East Park Energy construction traffic evidence submission: construction material and delivery traffic reconciliation, omitted traffic categories and wider transport issues

Submission: For the attention of the Examining Authority, National Highways, Bedford Borough Council, Cambridgeshire County Council and Huntingdonshire District Council

1. Introduction: Construction traffic reconciliation, delivery categories and wider transport issues

Client
BSSL Cambsbed 1 Ltd
Project
East Park Energy
Drawing Title
**Indicative Construction Access
and Compounds
Key Plan (Sheet 0 of 5)**

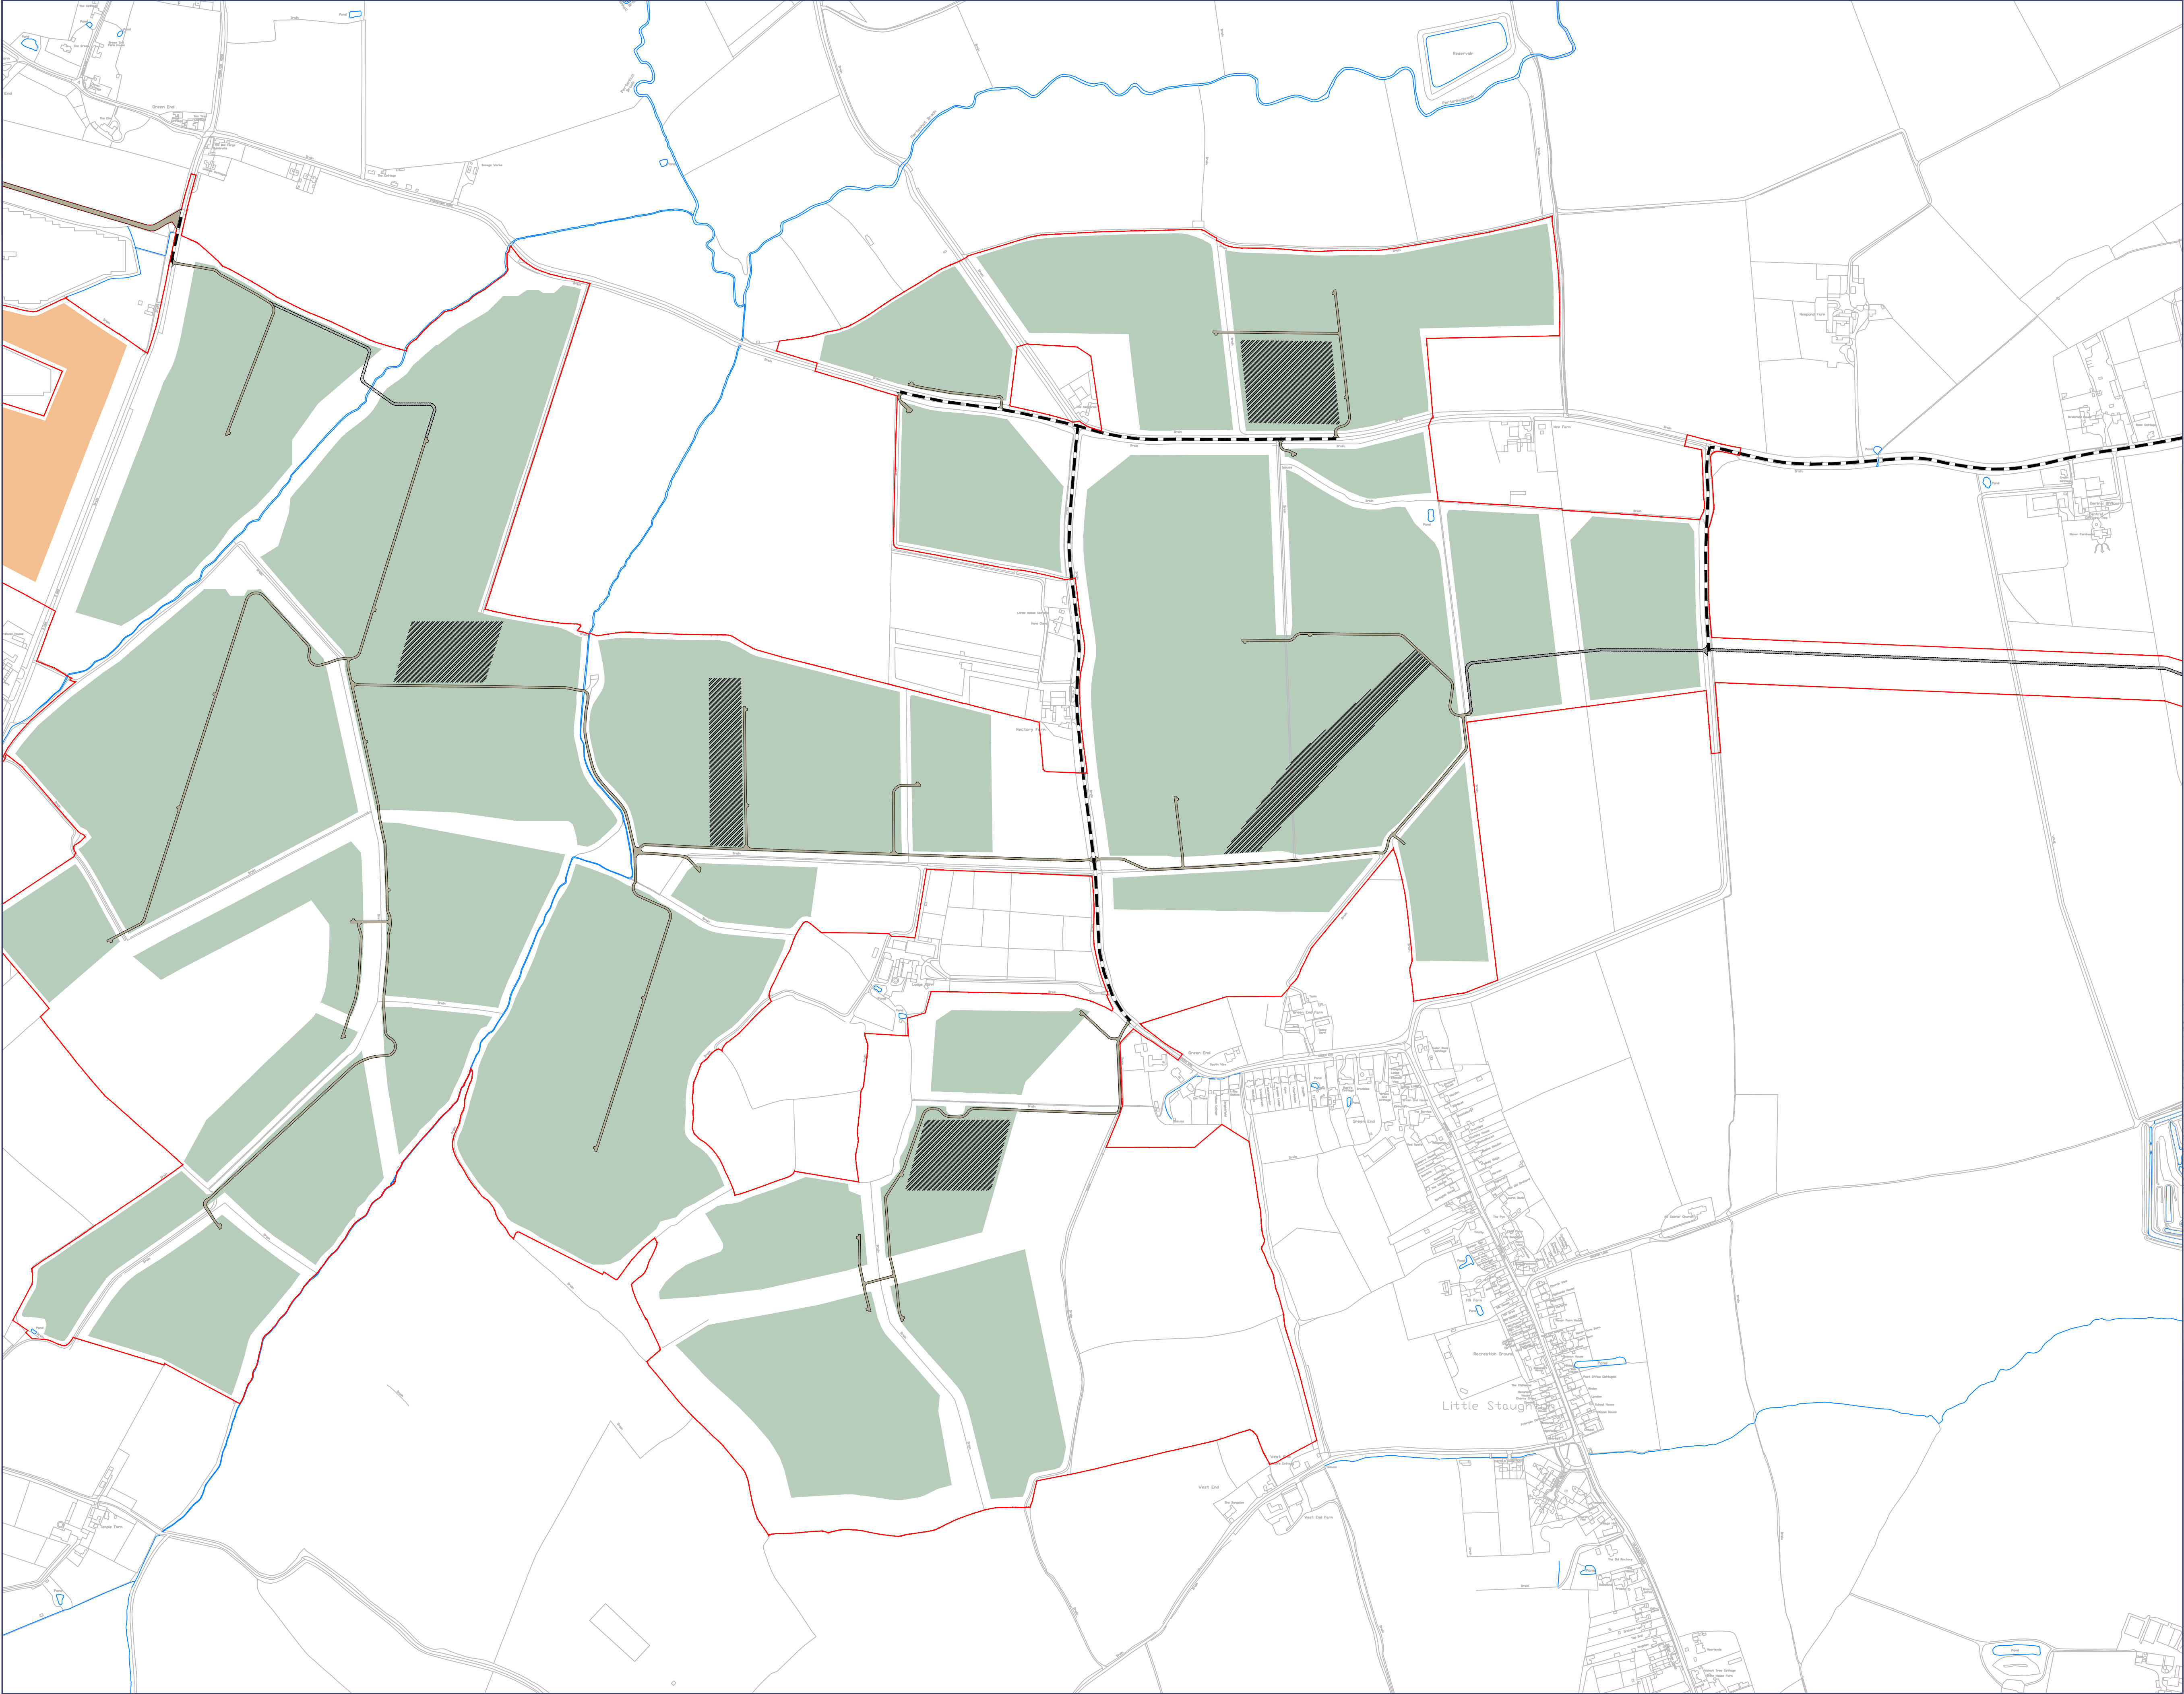
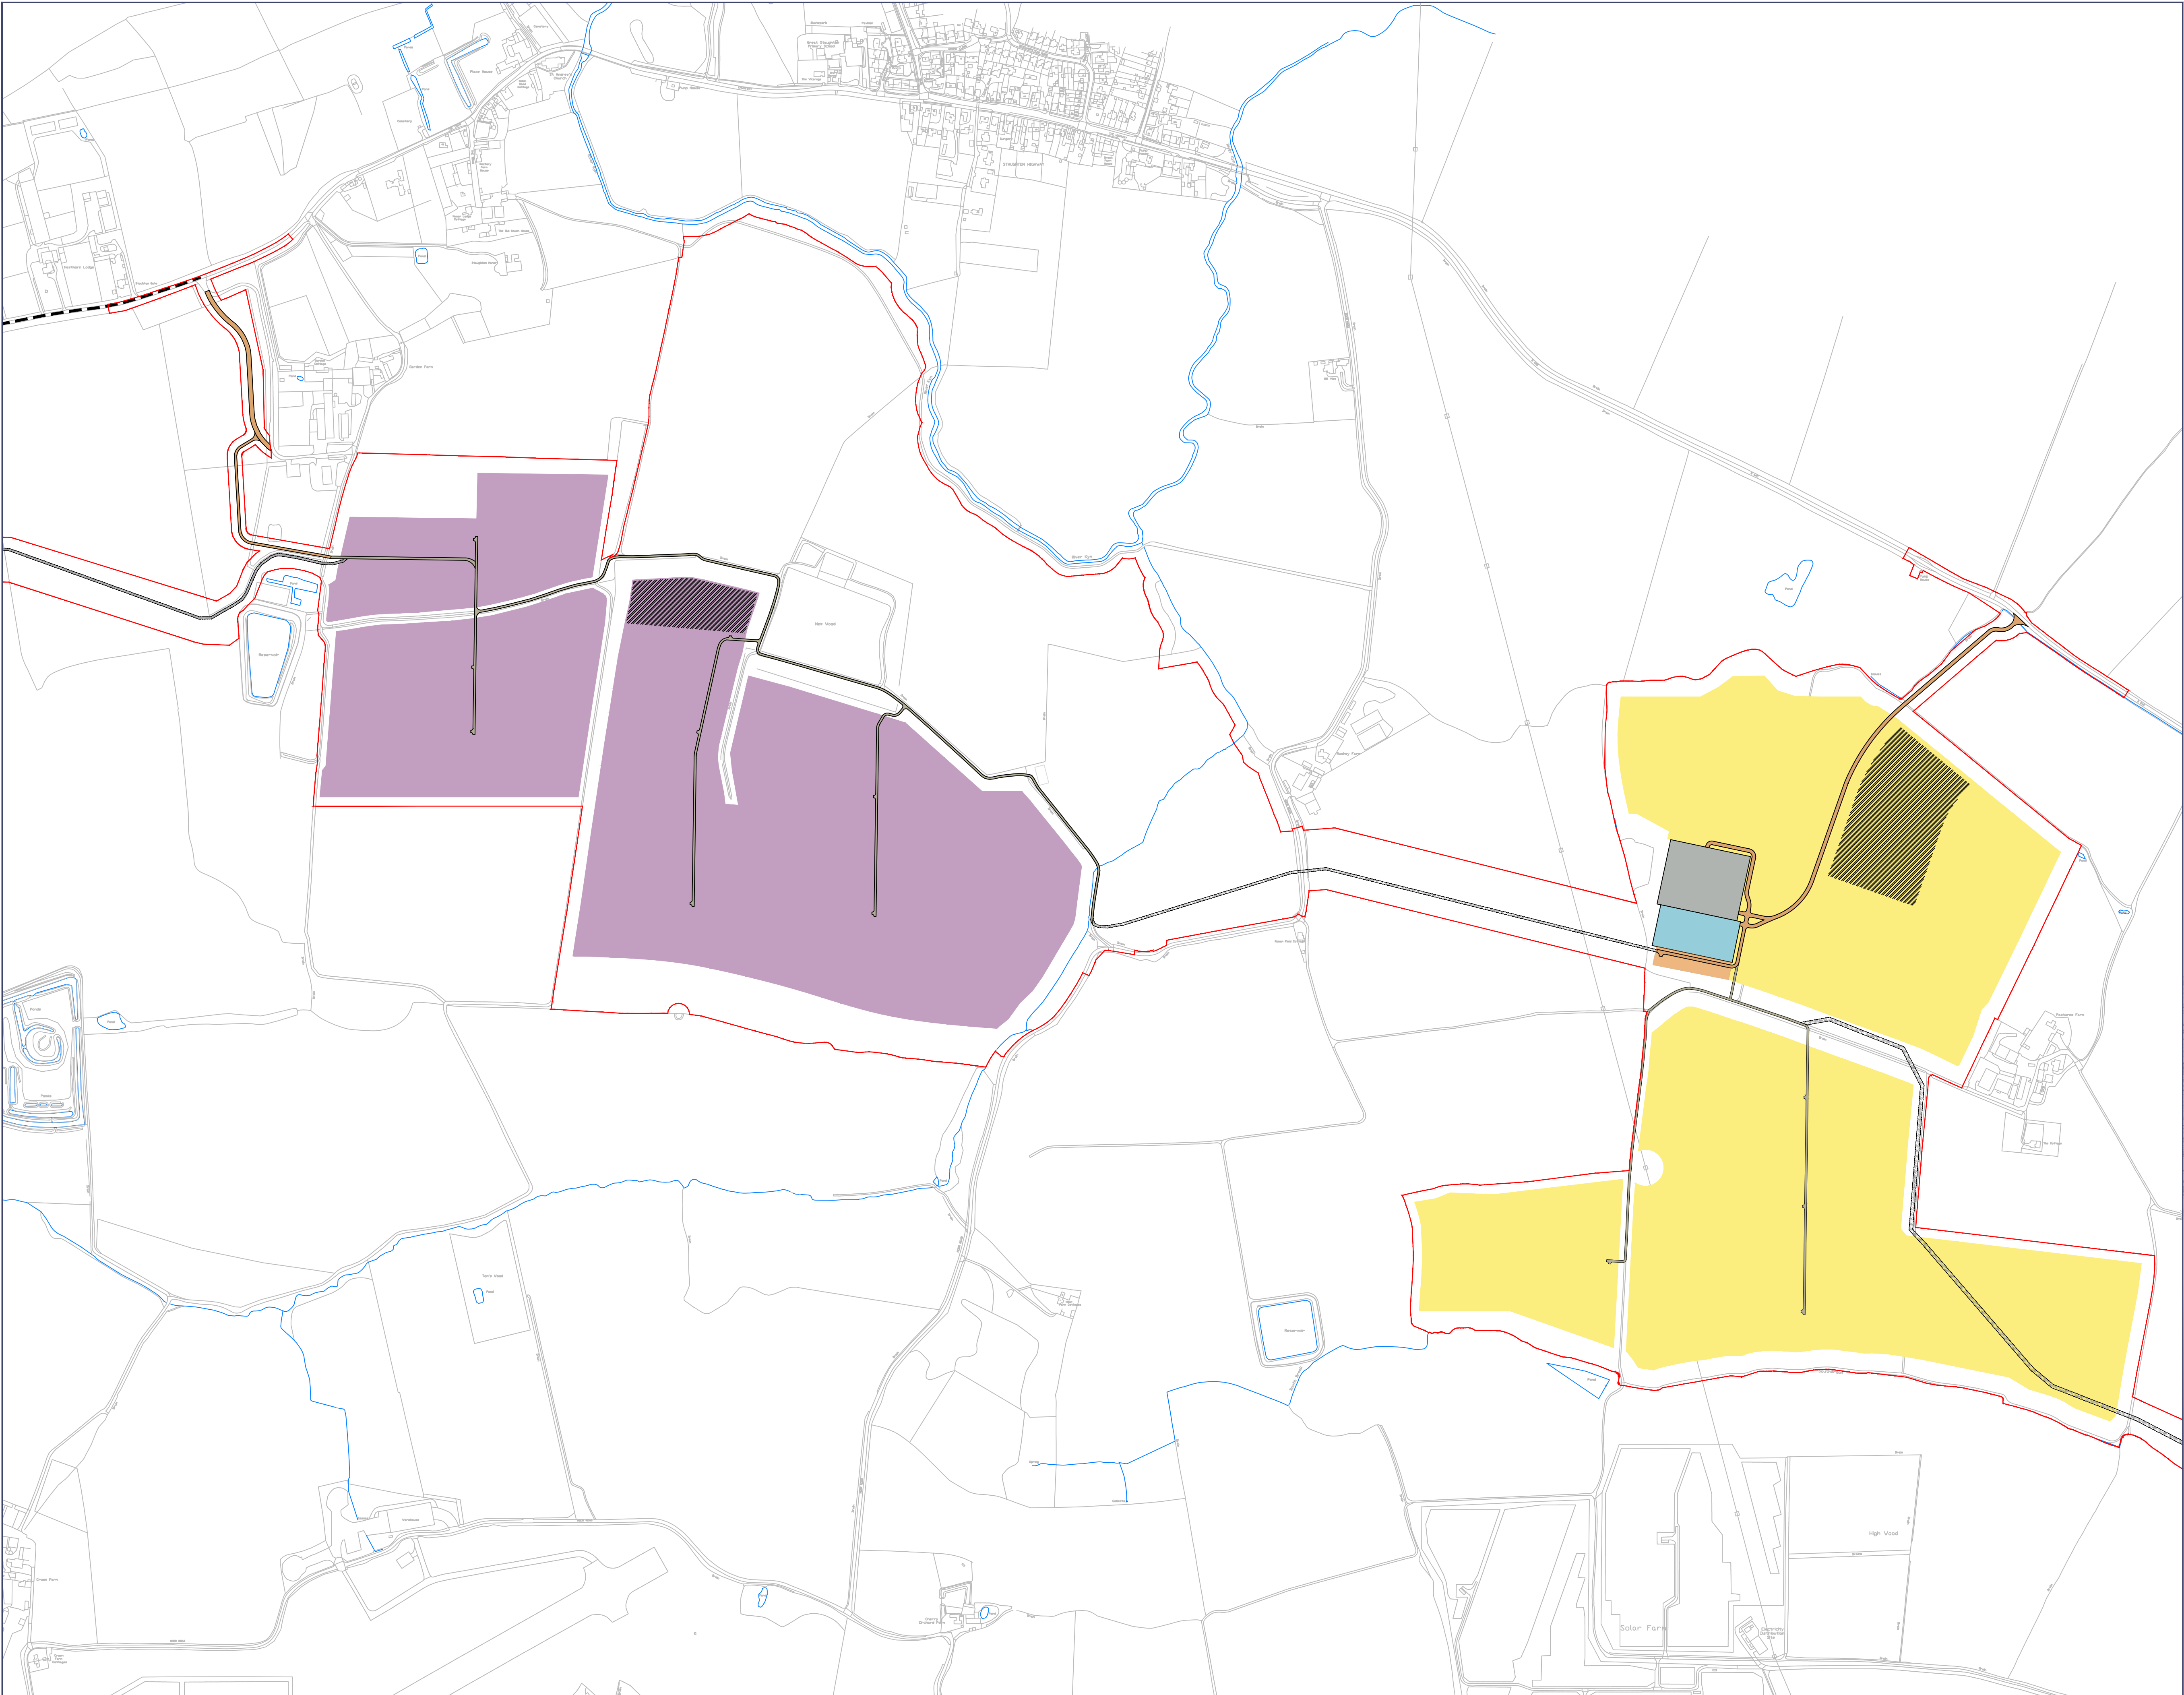
- **Pavement materials for car parks.** It is assumed that all the car parking areas at the main and 11 satellite compounds would be constructed using bituminous materials to provide a suitable surface for all vehicles and to avoid mud being deposited on the access tracks and local roads. Large areas of car parking are required to meet the requirements set out in paragraph 4.4.2 of the ‘Outline Construction Traffic Management Plan’ (REP3-050):

The HGV trips required to deliver any bituminous materials appear to have been omitted from the Applicant's construction traffic trip generation calculations. Similarly, any trips to deliver/remove all associated construction plant to lay and compact the road pavement layers of the car parks also appear to have been omitted.

- **Vehicles and plant movements associated with removal of some sections of the internal haul roads post-construction.** Under plans set out in Figure 15 'Proposed Construction Access Strategy' in Appendix C of the 'Outline Construction Traffic Management Plan' (REP3-050), SEPE calculates that up to 8.2km of tracks may be removed between:
 - Sites B and C,
 - Sites C and D, and
 - Site D and the Eaton Socon substation.

Accordingly, SEPE suggests that additional HGV trips would result on sections of Great Staughton Road, Spring Hill, B645 to the east of Great Staughton village and Moor Road during the replacement works and the decommissioning phase due to the removal of these sections of the internal haul road post-construction.

SEPE notes that more HGV trips would be generated if the removed sections of the internal haul roads were reconstructed for the replacement works and the decommissioning phase.
